**PREFERRED PROJECT REPORT  
MP 10\_0107**

**61 MOBBS LANE, EPPING – STAGE 1 TOWNHOUSE  
DEVELOPMENT**

**NOVEMBER 2010**

02 FIRST FLOOR PLAN

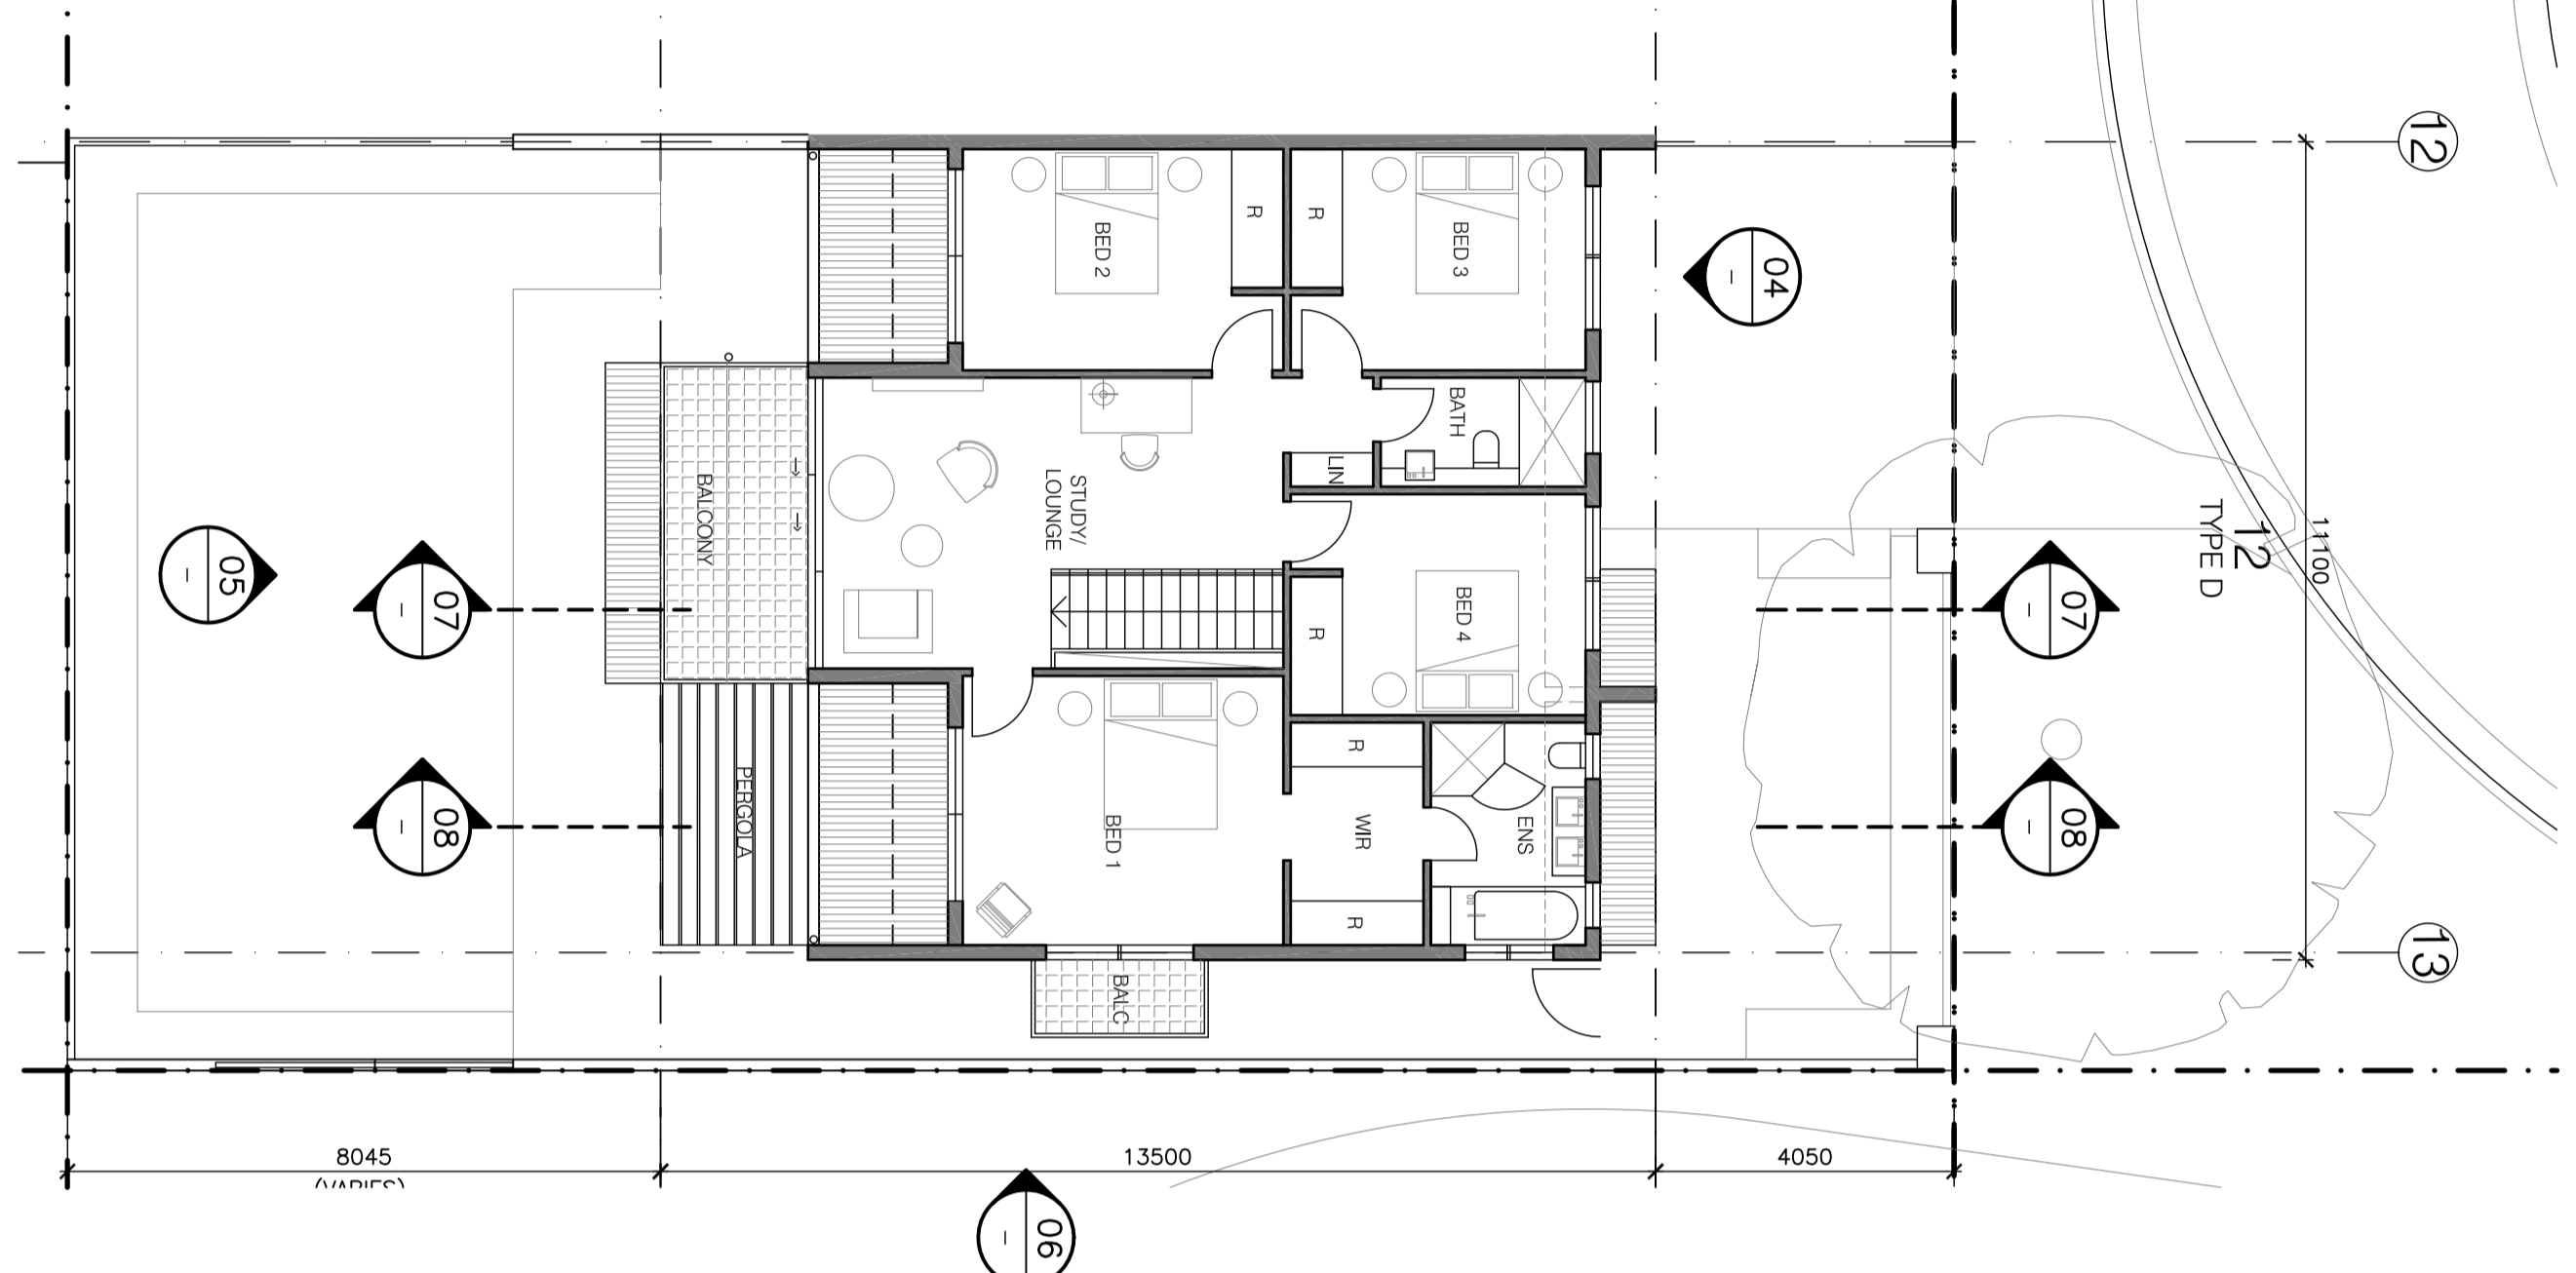
Issue: Private Open Space: The front fence should be a max. of 1.2m in height, 40m<sup>2</sup> per dwelling of private open space is required and no front yards are permissible

Response: The private open space is located to the rear of the dwelling to ensure that the space is private and useable. The front fences will not exceed 1.2m, as per the submitted architectural plans and the rear yards provided in building 3 are substantially in excess of 40m<sup>2</sup>. The size of the rear yards range from 106 – 187m<sup>2</sup>. Refer to **Annexure 1** which contains a schedule of areas for the rear yard.

| TITLE        | APPROVED: SP | A-3010<br>Project Application                                |

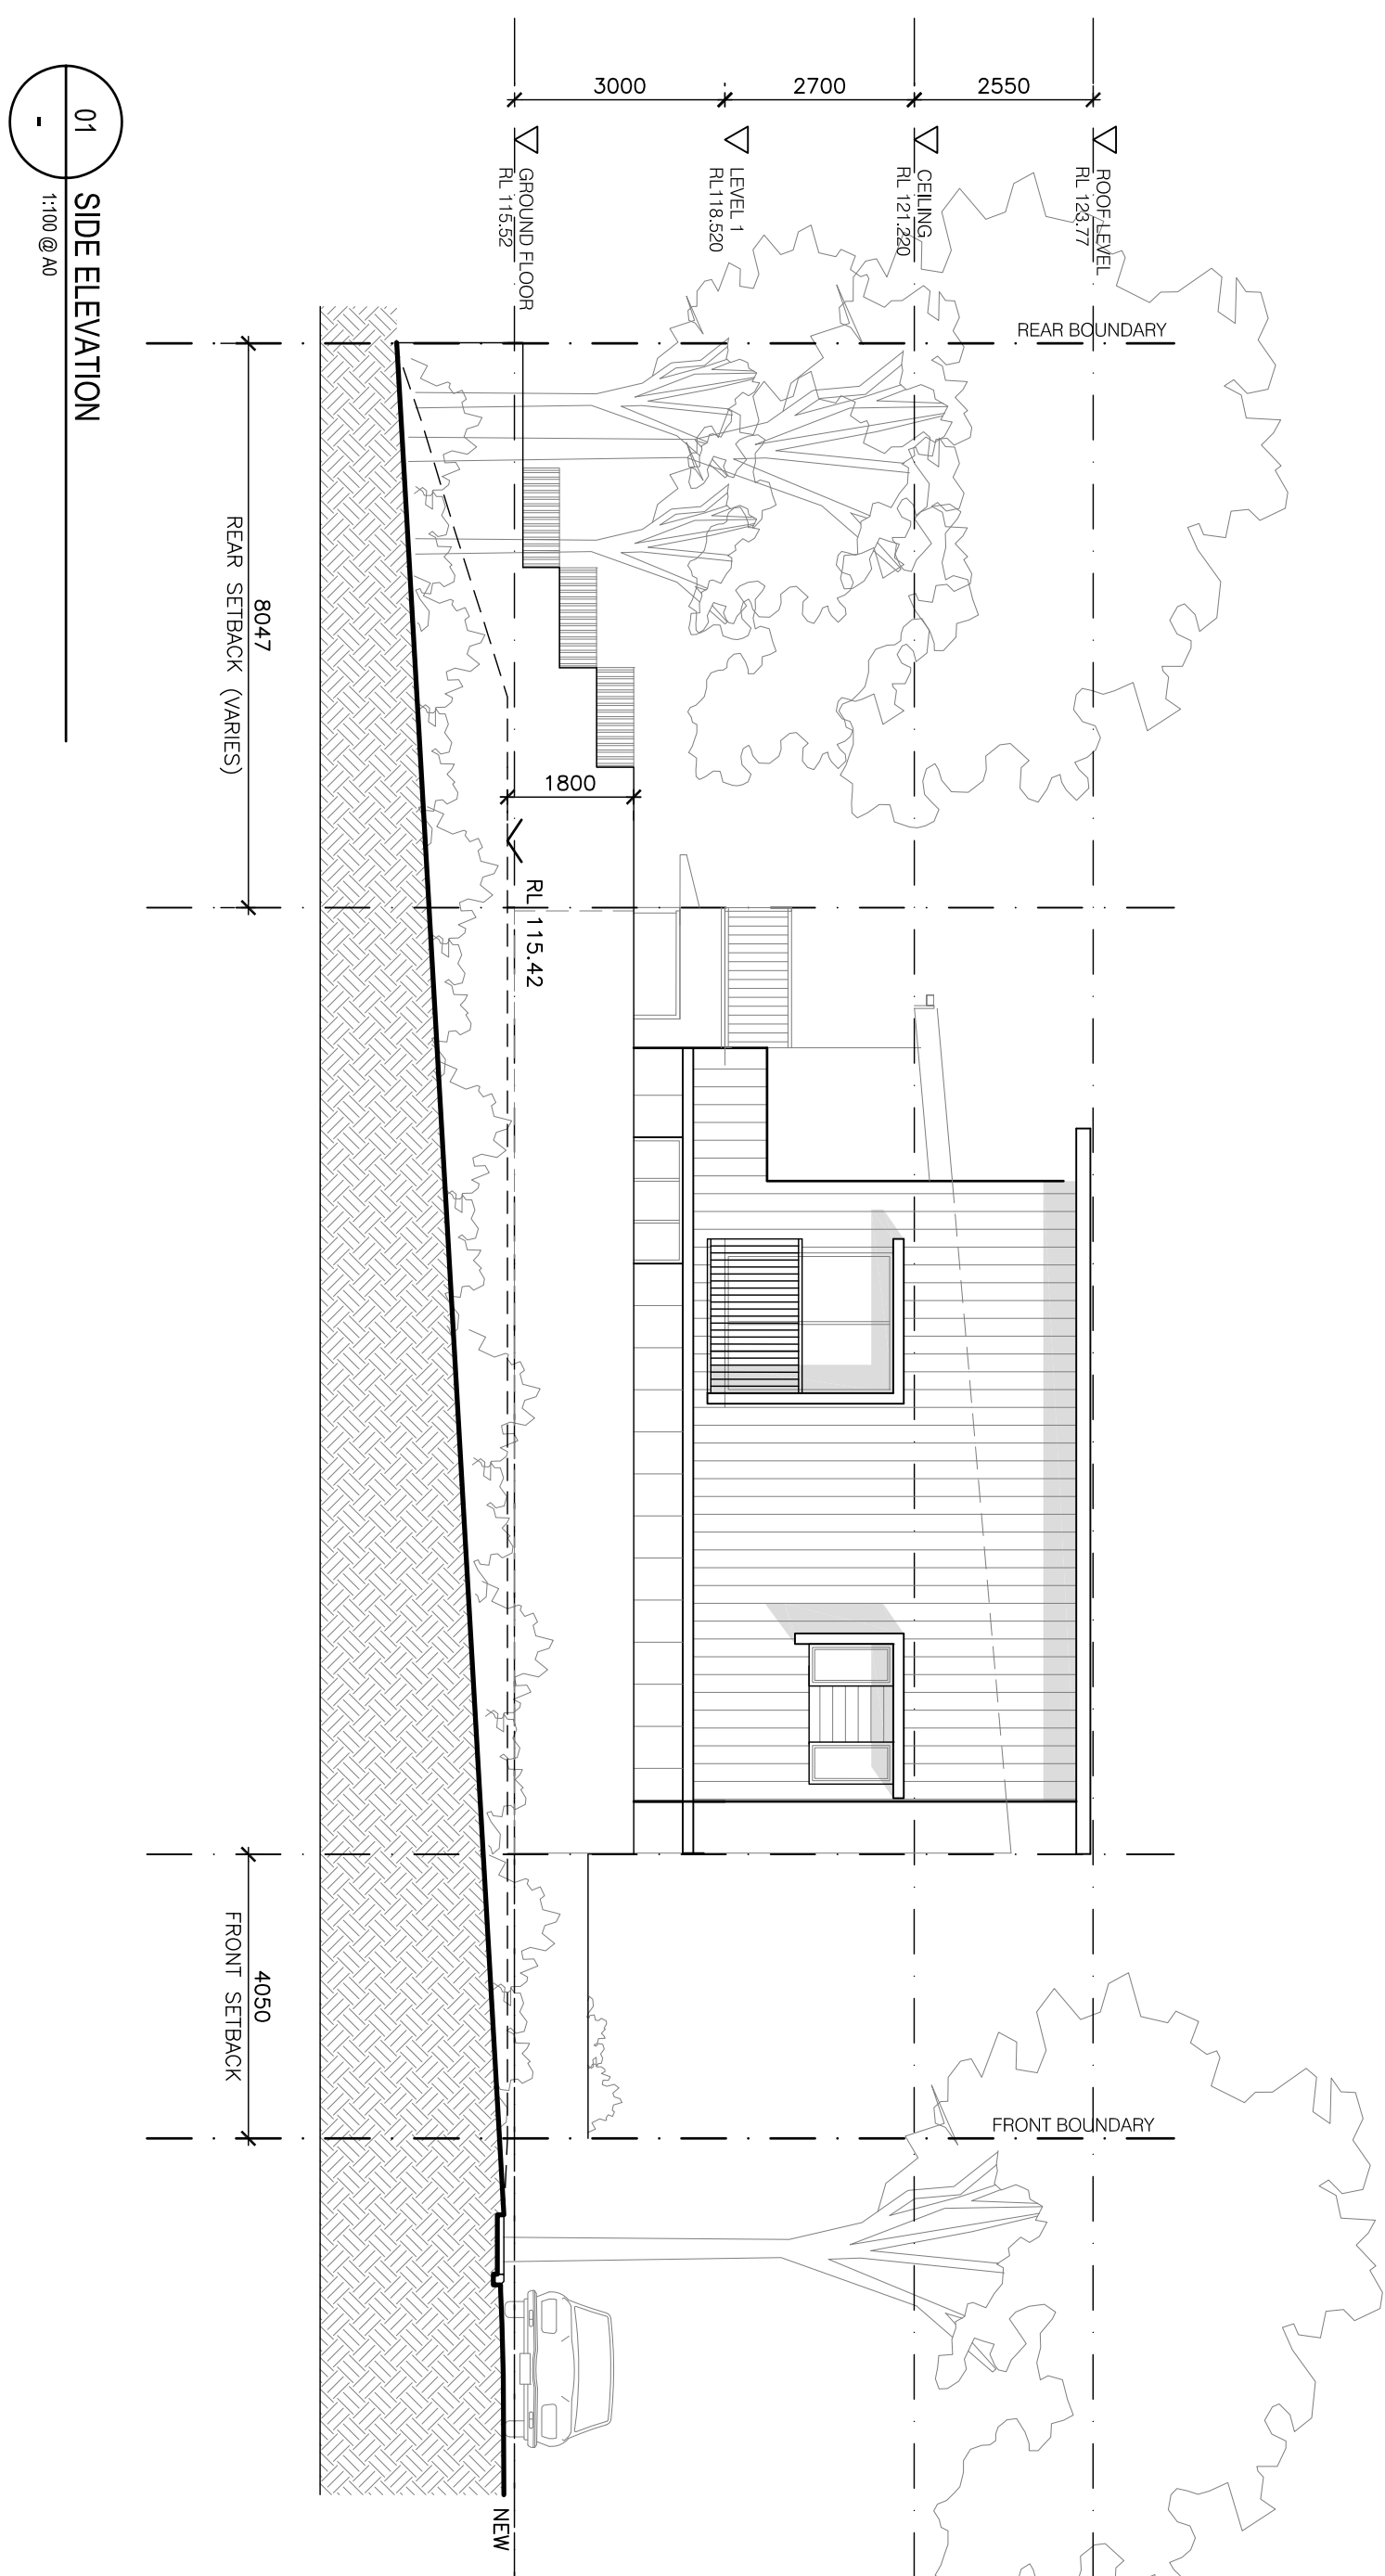
Issue: The balconies at the rear of Building 3 should be deleted.

Response: Balconies provide a valuable recreational and aesthetic function. They have been included to ensure ventilation into the building. They are also highly sought after by occupants.

Proposed landscaping treatment along the neighbouring properties in addition to fencing and the fall in the land, will ensure adequate privacy is maintained.
